**RE: SAD 228, Lot 9 Block 5 Unit 18
8008 Compass Dr. NW
Request for Permanent C.O. - Accepted
Engineers Stamp Date 12/8/14 (D10D003K9)
Certification Dated: 6-22-15**

Project Title: Lot Grading Abrayo Lot Building Permit #: _____ City Drainage #: D10D003K9

LOT 9, BLOCK 5, UNIT 18 VCS
8008 COMPASS DRIVE, NW
GRADING PLAN

LOT 9, BLOCK 5, UNIT 18 VCS
8008 COMPASS DRIVE, NW
GRADING PLAN

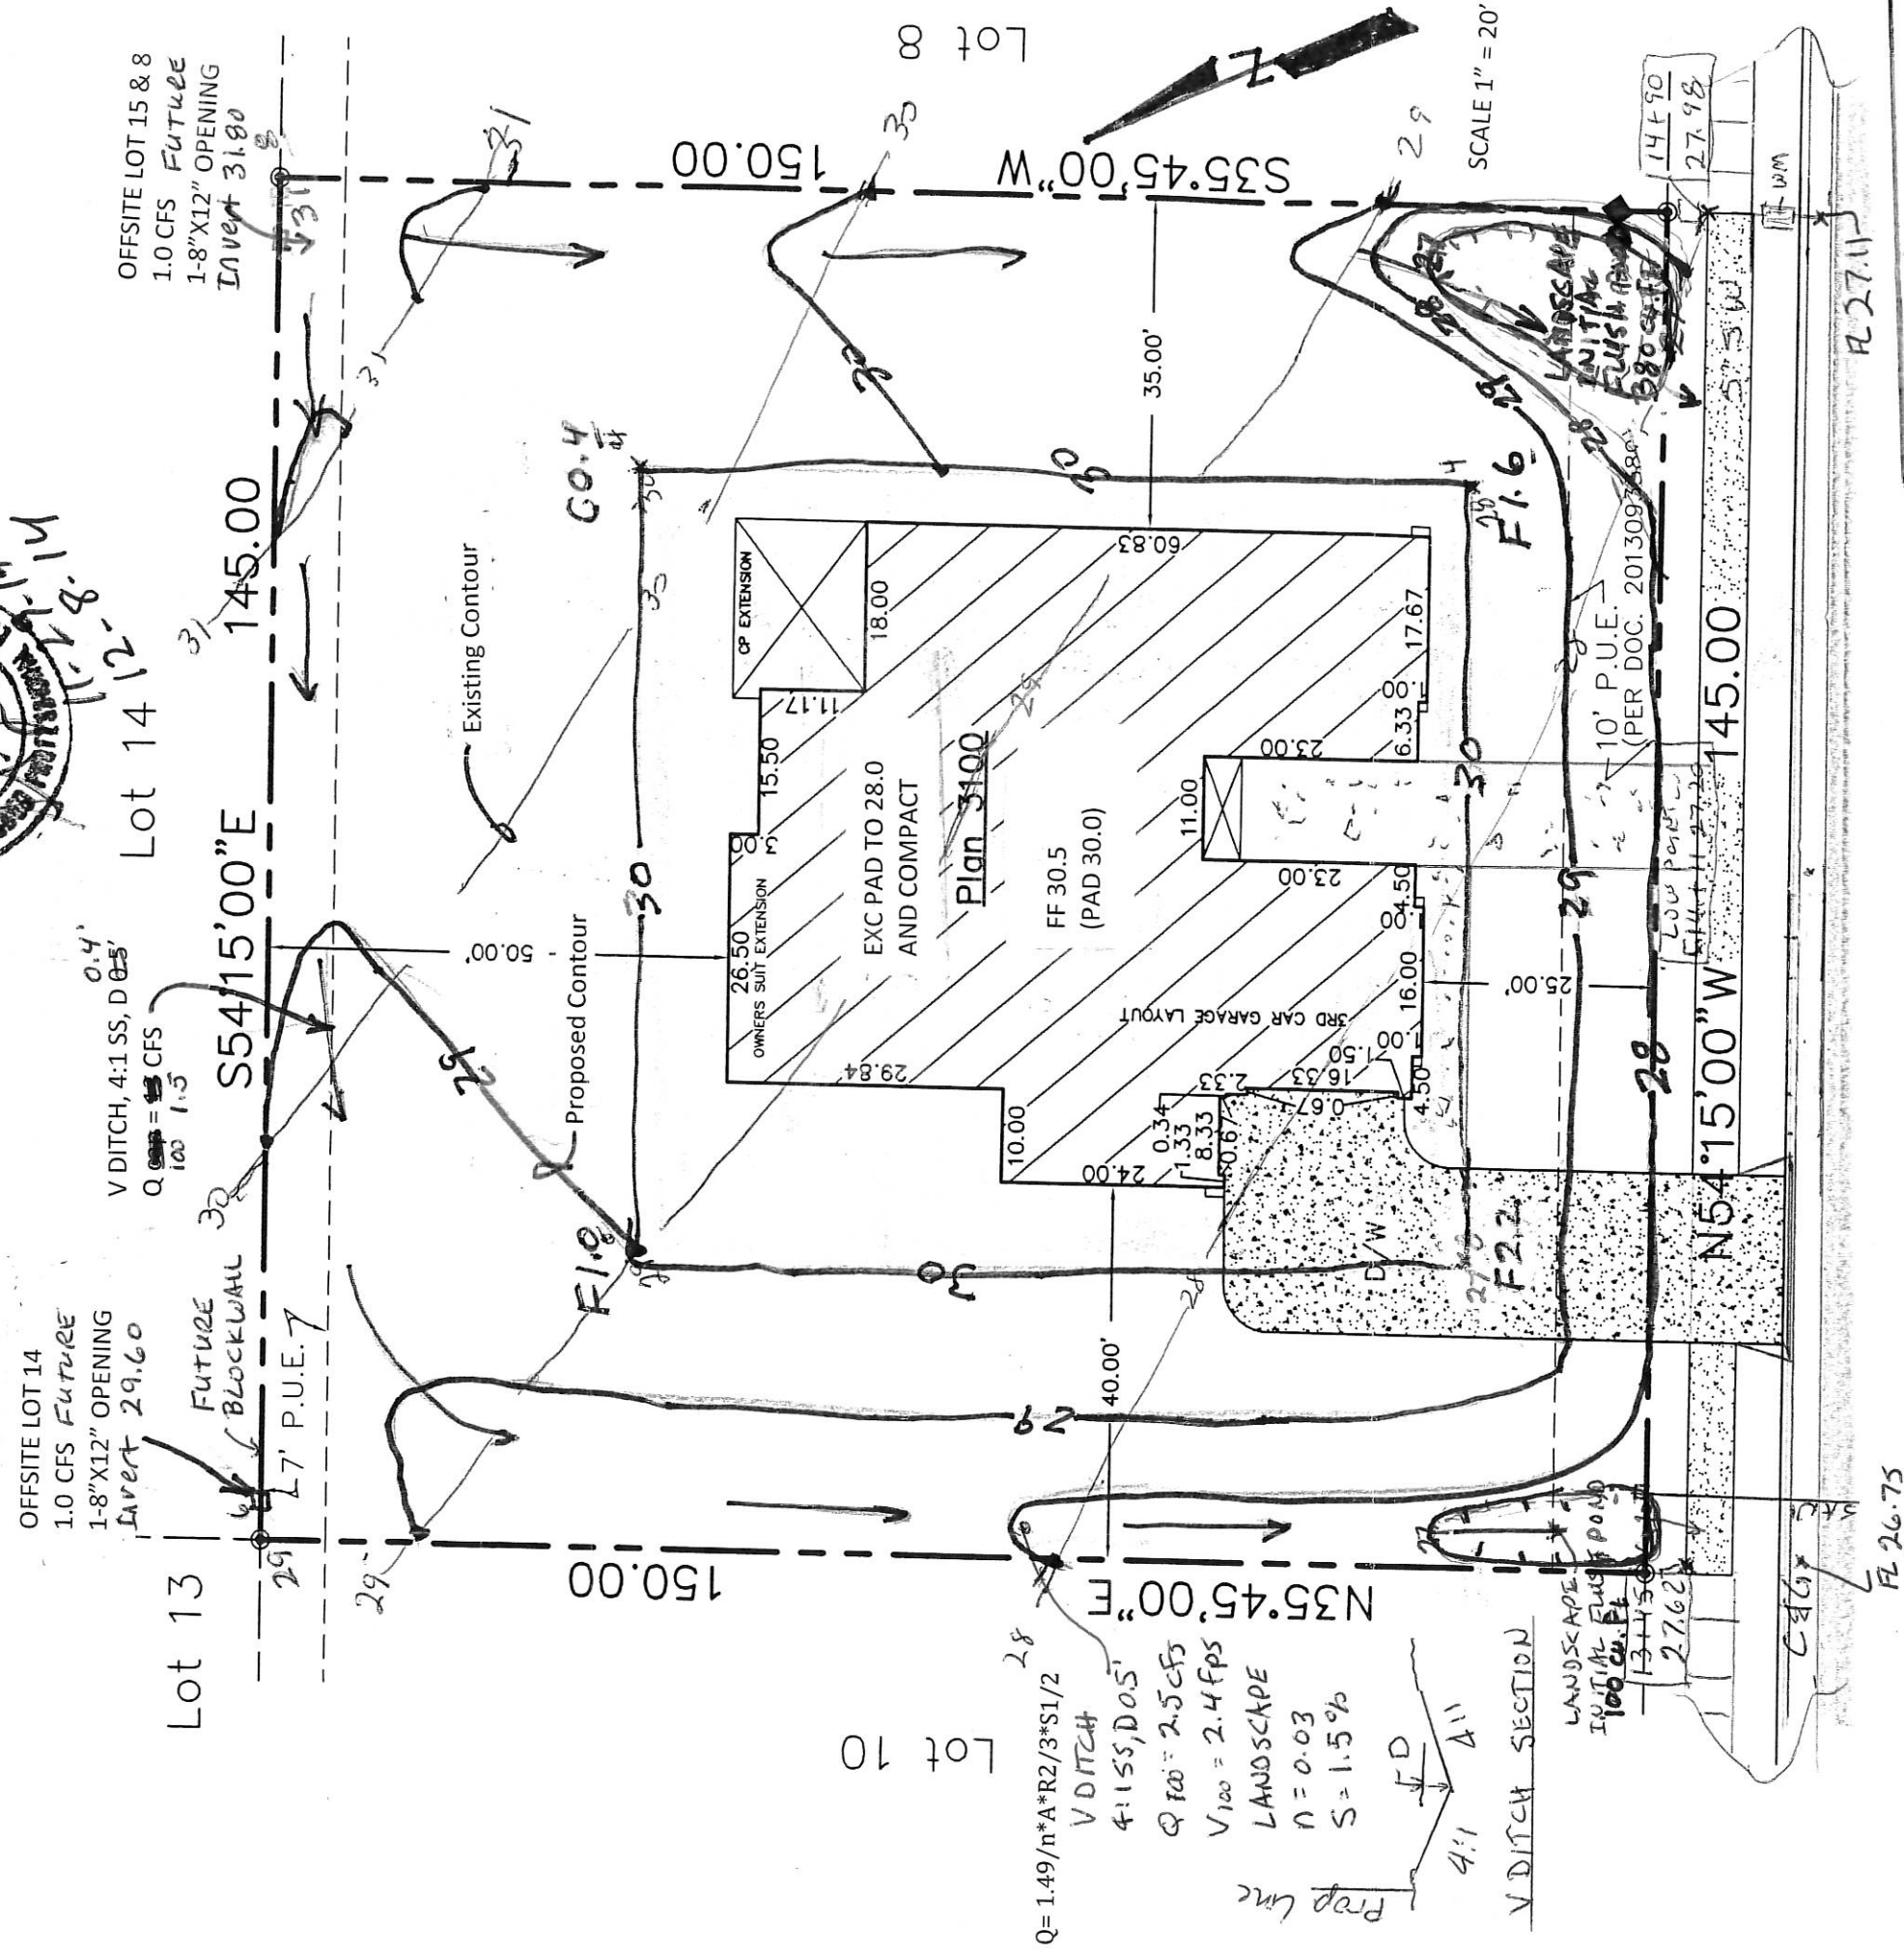
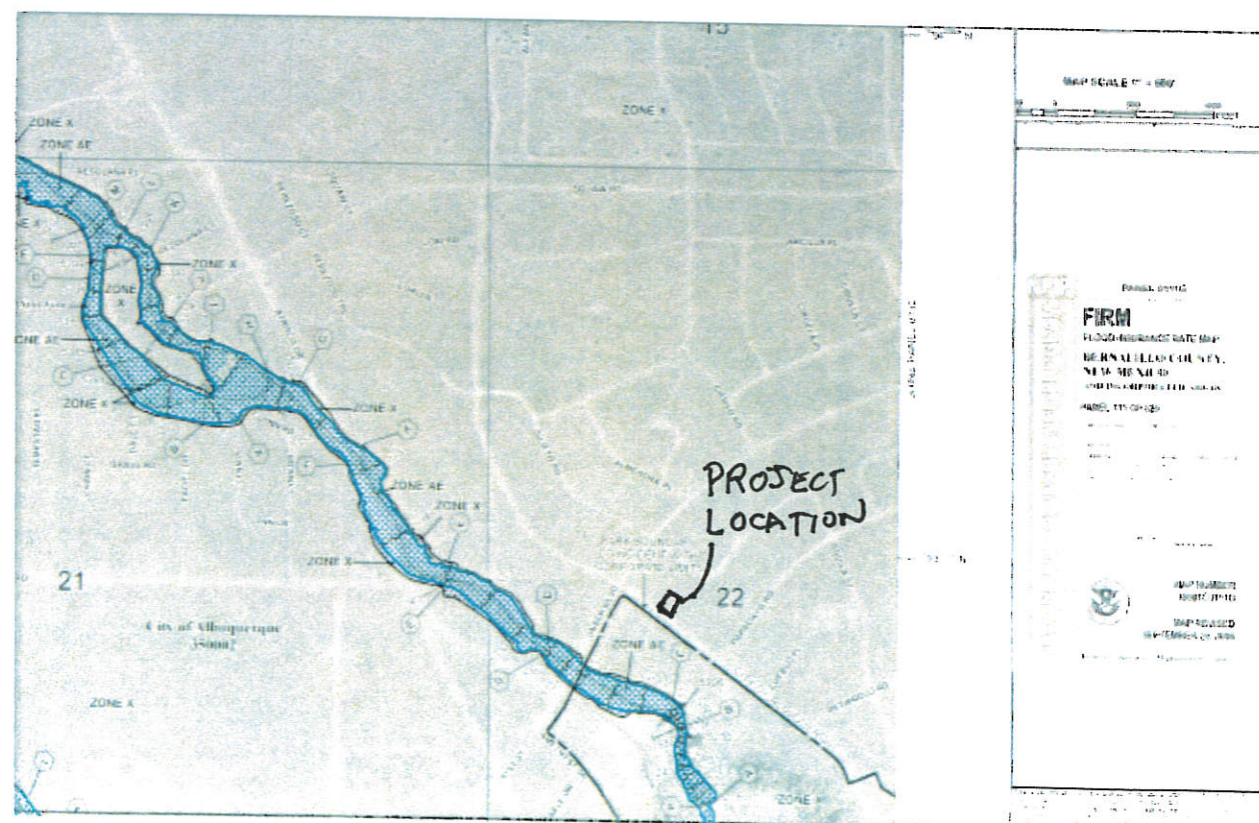
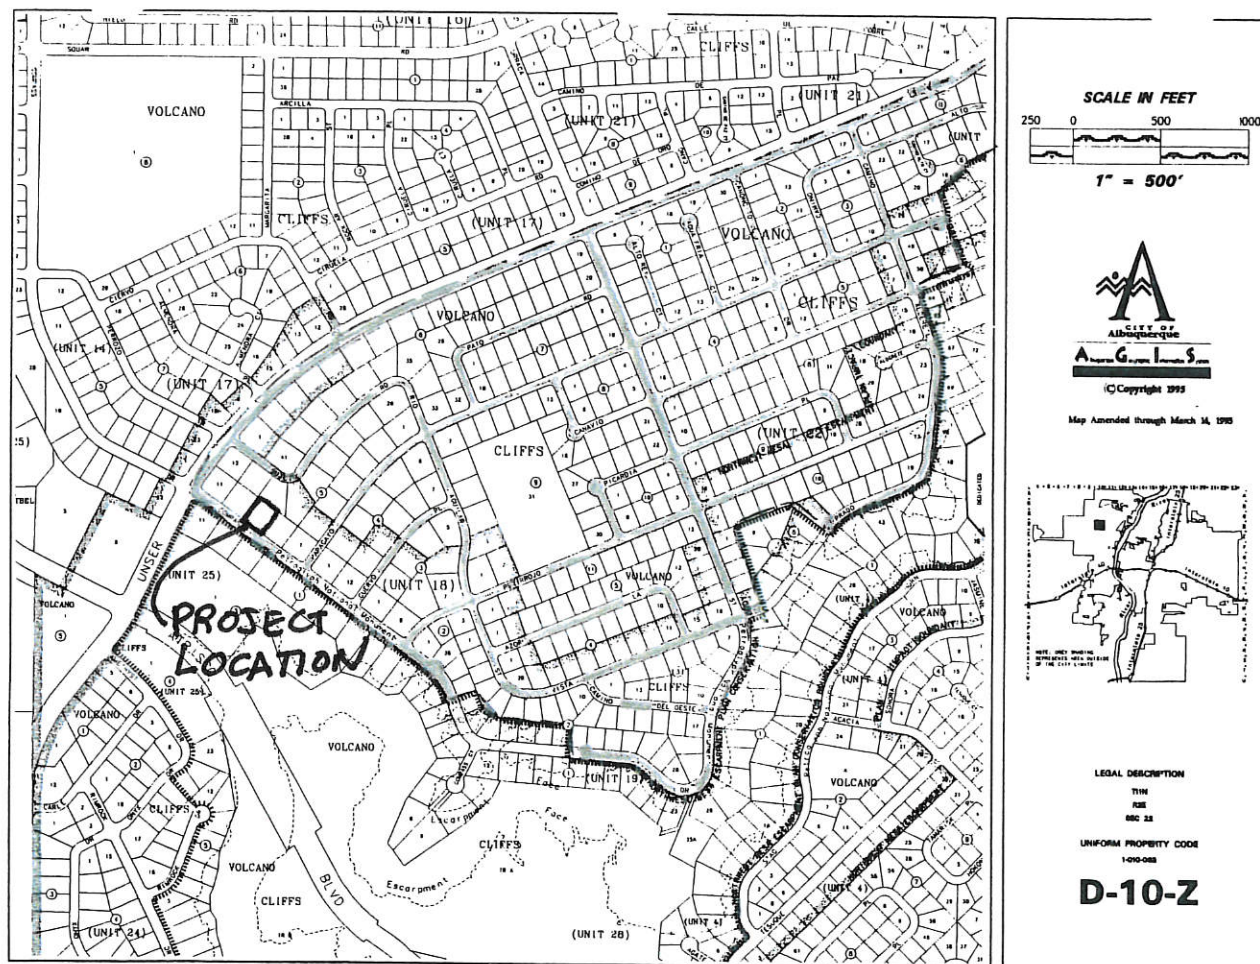
- Provide a Vicinity map, a FEMA map or designation, a narrative. *on cover*
- Mention of the first flush per EPA standards is required. The amount required is .34" times the impervious area. *on cover*
- Provide a section of the V Ditch and calculations for the ditch. 13.0cfs seems a bit too much. Is the ditch a shared ditch, *if so where will the block fence be placed?* *NO*
- What are the inverts of the openings? Is this a block fence? *FUTURE*
- What is the flow line in the street? ✓
